Ref: 2024/O122

Please see below comments on behalf of South Yorkshire Mayoral Combined Authority (SYMCA) regarding the following planning application - please note that these comments represent the views of officers and do not represent the formal views of SYMCA unless this is specifically stated:

Description: *Outline planning application for demolition of existing structures and erection of residential dwellings with associated infrastructure and open space. All matters reserved apart from access into the site.*

Location: *Land north of Hemingfield Road, Hemingfield, Barnsley*

Figure 4.3 – Location of Nearest Bus Stops

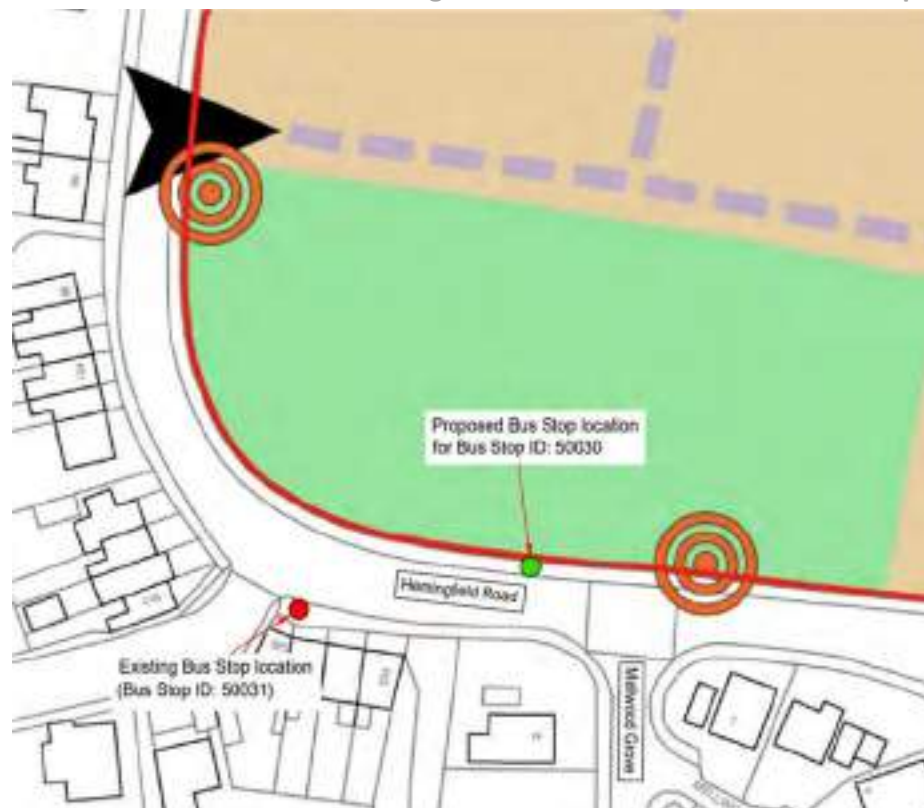
As set out in the application proposals bus stop 50030 will be relocated in order to allow for a new access to the application site to be constructed. The application proposes relocating the bus stop c. 75m south-east of its current location, on Hemingfield Road south of the proposed development. As the land behind the pavement falls away, in order to locate a bus stop with shelter here we would ask the applicant to commit to the space for a bus stop as well as agreeing to undertaking the works necessary to create a platform on which a bus shelter can be installed.

We seek assurance that the relocated bus stop will be provided with a convenient and legible pedestrian link to the development.

As set out above the proposals require bus stop 50030 to be moved in order to allow for the new access, and the applicant has proposed moving the bus stop c. 75m south-east of its current location. The proposed location has constraints that can be overcome if addressed early on (see below).

We request that the applicant undertakes the works required to provide a development platform for the relocated bus stop 50030 (to be managed by way of planning condition and/or S106 agreement), as well as providing accessible pavement works including raised kerbs, tactile paving, and bus stop clearway marking to bus stops 50030 and 50031 (to be managed by a S278 agreement).

We request that the applicant provides the costs for bus waiting shelters fitted with R-T PID at stops 50030 and 50031 (to be managed by way of S106 agreement). Indicative designs of the bus shelters and R-T PIDs are shown at Annex 1.
